**MODIFICATION REQUEST  
DRY DOCK STORAGE AND MARINE  
FACILITY, ROZELLE BAY**

***MP 06\_0210 MOD 4 – Proposed Modifications  
to the Western Boat Store***

Director-General's  
Environmental Assessment Report  
Section 75W of the  
*Environmental Planning and Assessment Act 1979*

August 2012

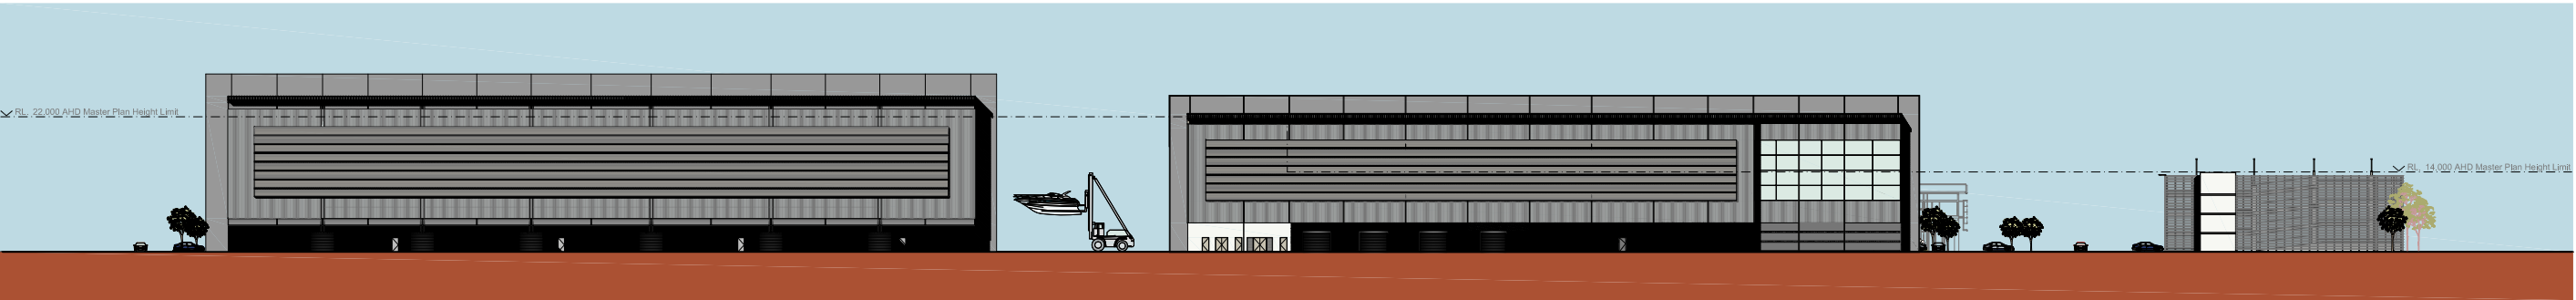
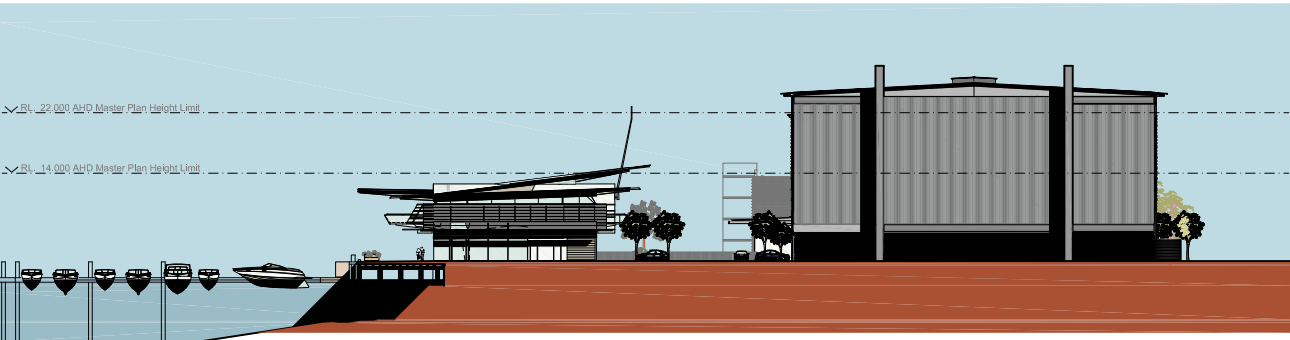
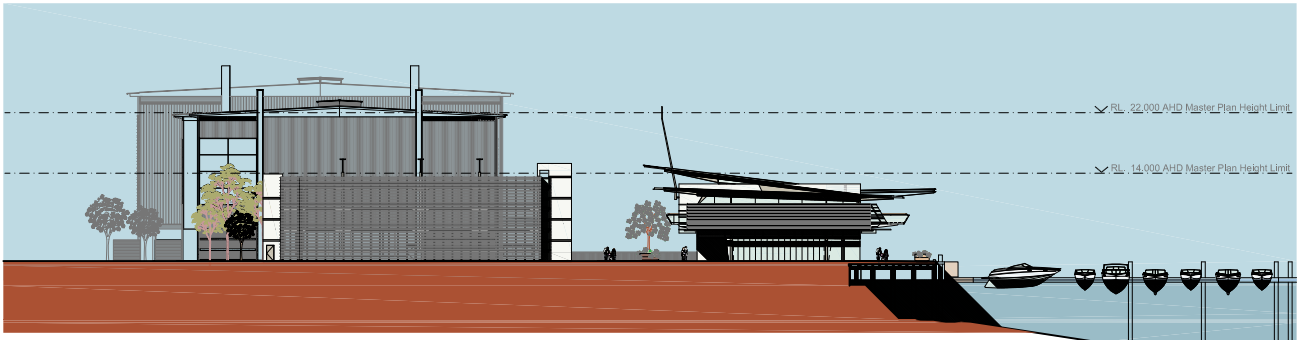
- The project approval has lapsed as no Construction Certificate was lodged to commence work prior to 21 May 2011.
- The buildings do not reflect the design requirements of the *Rozelle and Blackwattle Bays Maritime Precincts Master Plan 2002* (Rozelle and Blackwattle Bay Master Plan) as referenced in the master lease agreement.
- The design and site coverage of the buildings exceeds those in the Rozelle and Blackwattle Bay Master Plan without proper planning justification.
- The pedestrian and cycle promenade connection from Rozelle Bay to the Glebe Island Bridge, which is identified in the Sharing Sydney Harbour Access Plan and the Rozelle and Blackwattle Bay Master Plan is along Maritime Close which runs through the site. It needs to be 24/7 and wide enough to be part of the promenade system.

principles and provisions of the Rozelle and Blackwattle Bay Master Plan. Notwithstanding, the department is concerned that that the colour palette of the modified schedule of finishes will reduce the perception of articulation within the façade in comparison to the original scheme.

- Departures from the Rozelle and Blackwattle Bay Master Plan were justified by SHFA as part of its assessment of the original project application. Furthermore, Condition A2(h) of the project approval required design modifications to reduce the bulk and scale of the eastern boat store and car park structure to provide consistency with the intent of the Rozelle and Blackwattle Bay Master Plan. The proposed modifications will not increase the height of the eastern boat store beyond that permitted under Condition A2(h).

In order to rectify this issue, the department has recommended a modification to Condition A2(h) to require the proponent to update the approved schedule of finishes to include all new materials proposed under the modification, and provide highlight colours that emphasise the underlying structure of the building, and articulate the individual building elements as per the provisions of the Rozelle and Blackwattle Bay Master Plan.
